October 2, 2020

Power Home Solar and Roofing
919 North Main Street
Mooresville, NC 28115

RE: Structural Roof Evaluation for the *Raynor Residence: 433 West Stewart Street, Coats, North Carolina*

SHEET NUMBER
PV-3

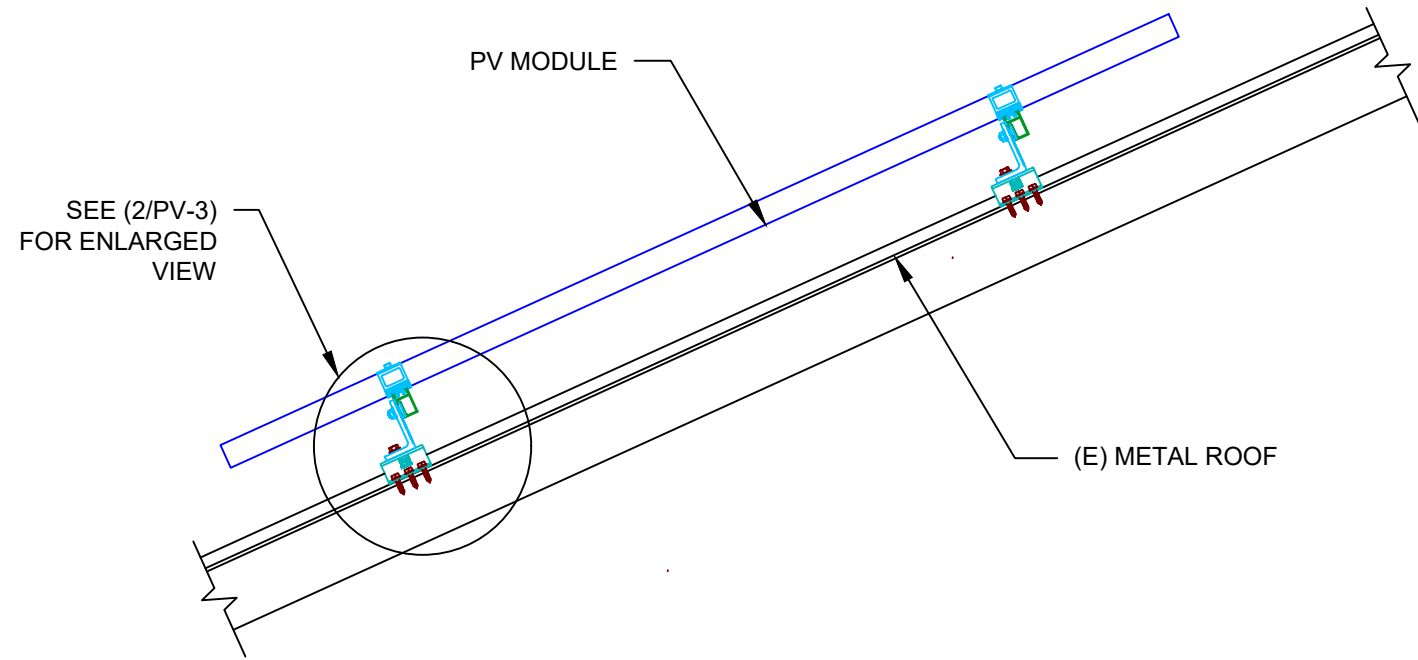
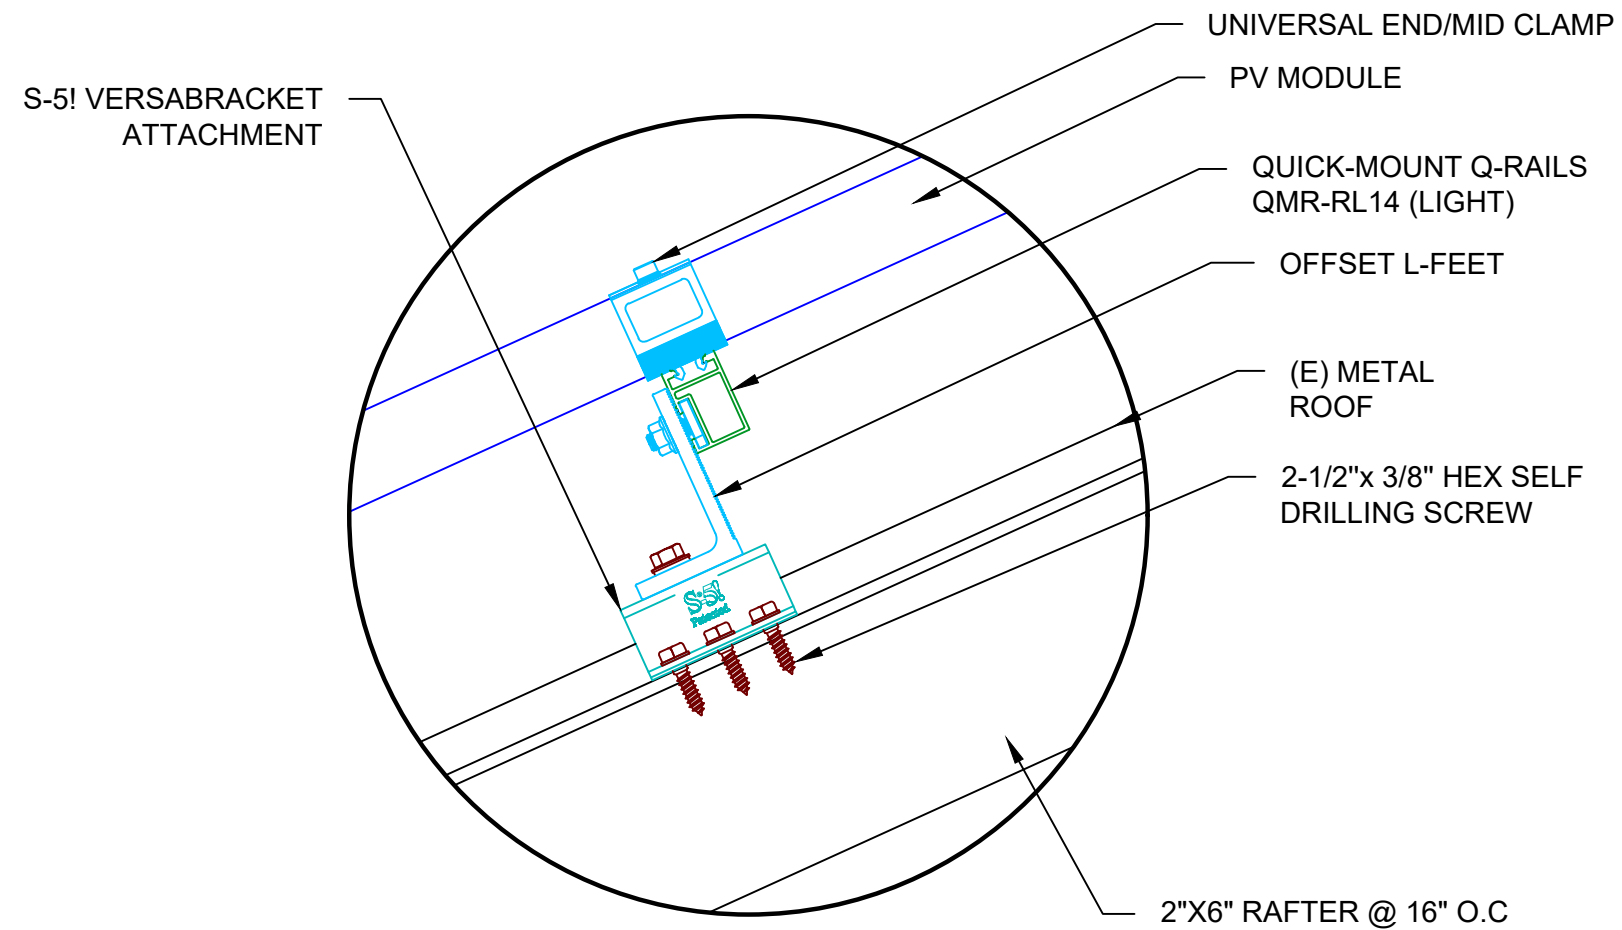
Based on our analysis we have determined that the existing roof framing will not adequately support the additional loads imposed by the solar panels. It is our recommendation that additional web members are added to all rafters at 24" o.c. according to SK-1 in order for the roof structure to adequately support the additional loads of the solar panels. A minimum of 35 protea roof attachments should be staggered such that the loads are evenly distributed. The racking system should be installed per the manufacture's specifications. Waterproofing around the roof penetrations is the responsibility of others. Right Angle Engineering assumes no responsibility for improper installation of the solar panels.
